From: parish.council@wiswell.plus.com
Sent: 26 March 2012 12:42
To: Graeme Thorpe
Subject: Re: FW: Pepper Hill, Wiswell

Thank you for your email and attachment (drawing 4206-06) regarding the planning application at Pepper Hill on Pendleton Road in Wiswell. The Members of Wiswell Parish Council are now satisfied that the property, if constructed, will meet the relations of the levels on the site.

Section AA

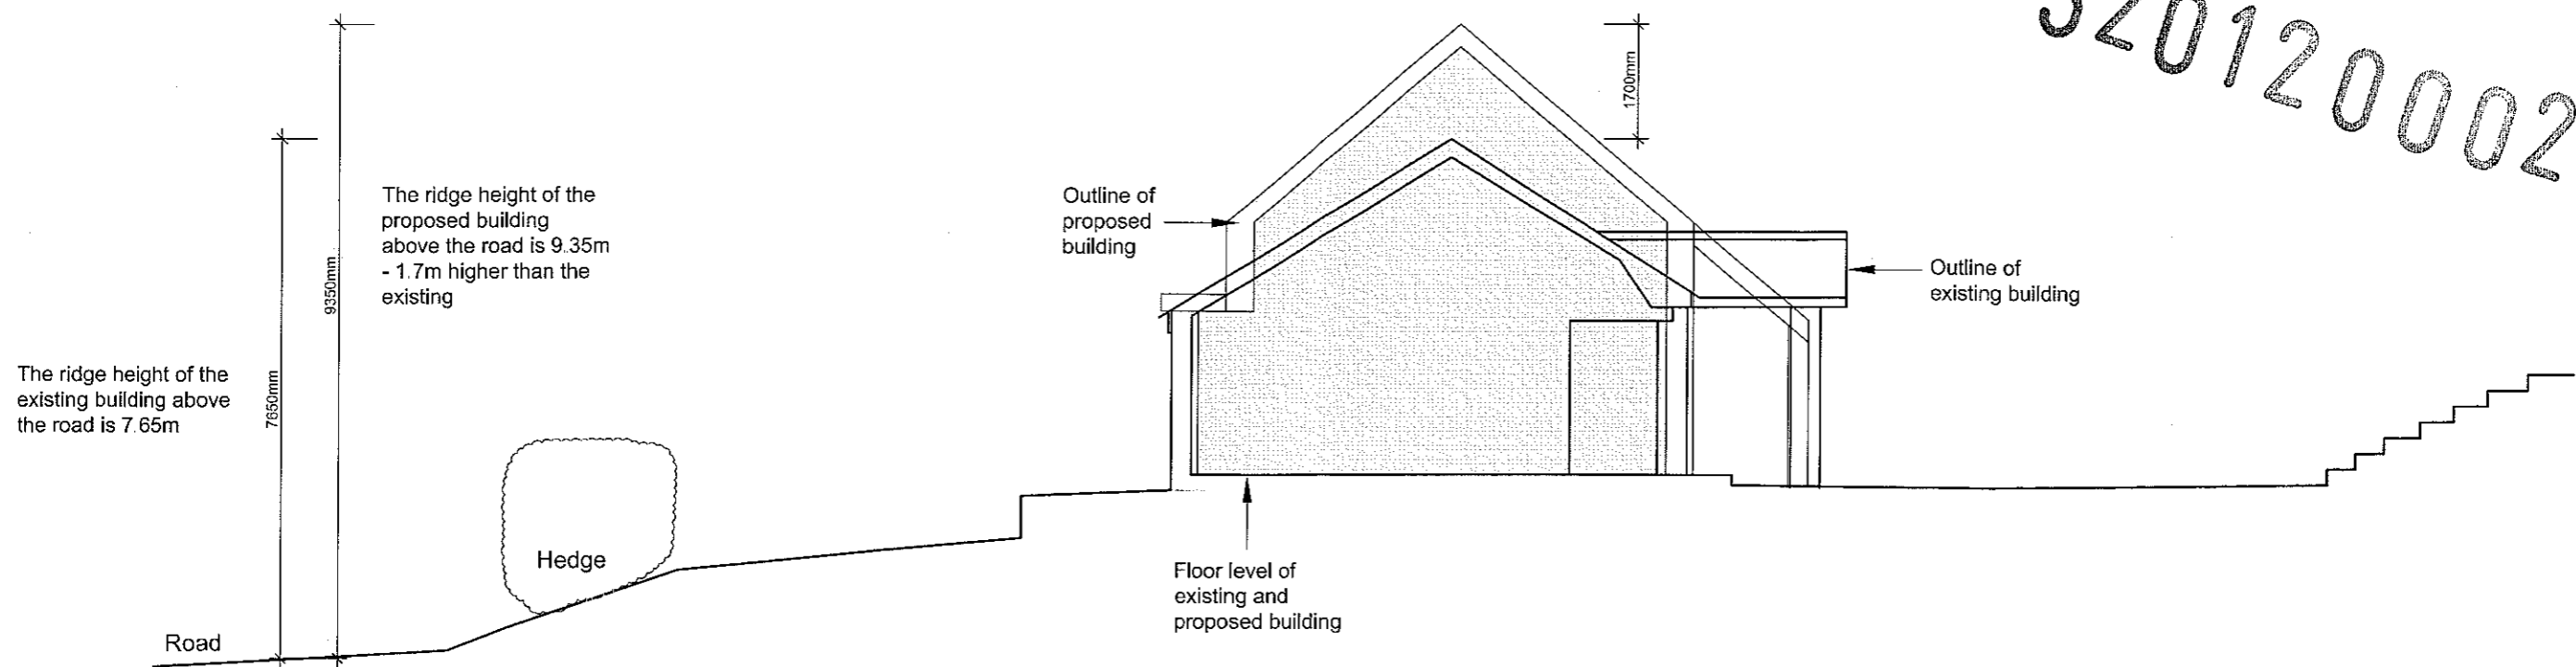
> FAO Mrs Victoria Wilson & Parish Council members,
>
> Upon receipt of your comment dated the 7th of February, the Agent has sent me a plan through indicating the exact level of the finished ground floor. This will ensure that when constructed, if approved by Planning Committee, it meets the relations of the levels on the site.
>
> I hope this is of some help to you.
>
> Regards,
>
> Graeme Thorpe BA (Hons) Dip TP MRTPI | Senior Planning Officer |
> Ribble Valley Borough Council, Council Offices, Church Walk,
> Clitheroe,
> Lancashire BB7 2RA
> T: 01200 414520 |
> F: 01200 414487 |
> E: graeme.thorpe@ribblevalley.gov.uk
> <mailto:graeme.thorpe@ribblevalley.gov.uk> |
> W: www.ribblevalley.gov.uk <http://www.ribblevalley.gov.uk/> |
>
>
>
> _____
> From: Louise Gill [mailto:Louise.Gill@sunderlandpeacock.com]
> Sent: 09 March 2012 09:30
> To: Graeme Thorpe
> Subject: Pepper Hill, Wiswell
>
>
> Graeme,
>
> Further to our discussion please find attached a section through the

site. You will note we have dimensioned the drawing to cover you with the datum of the floor and ridge height.
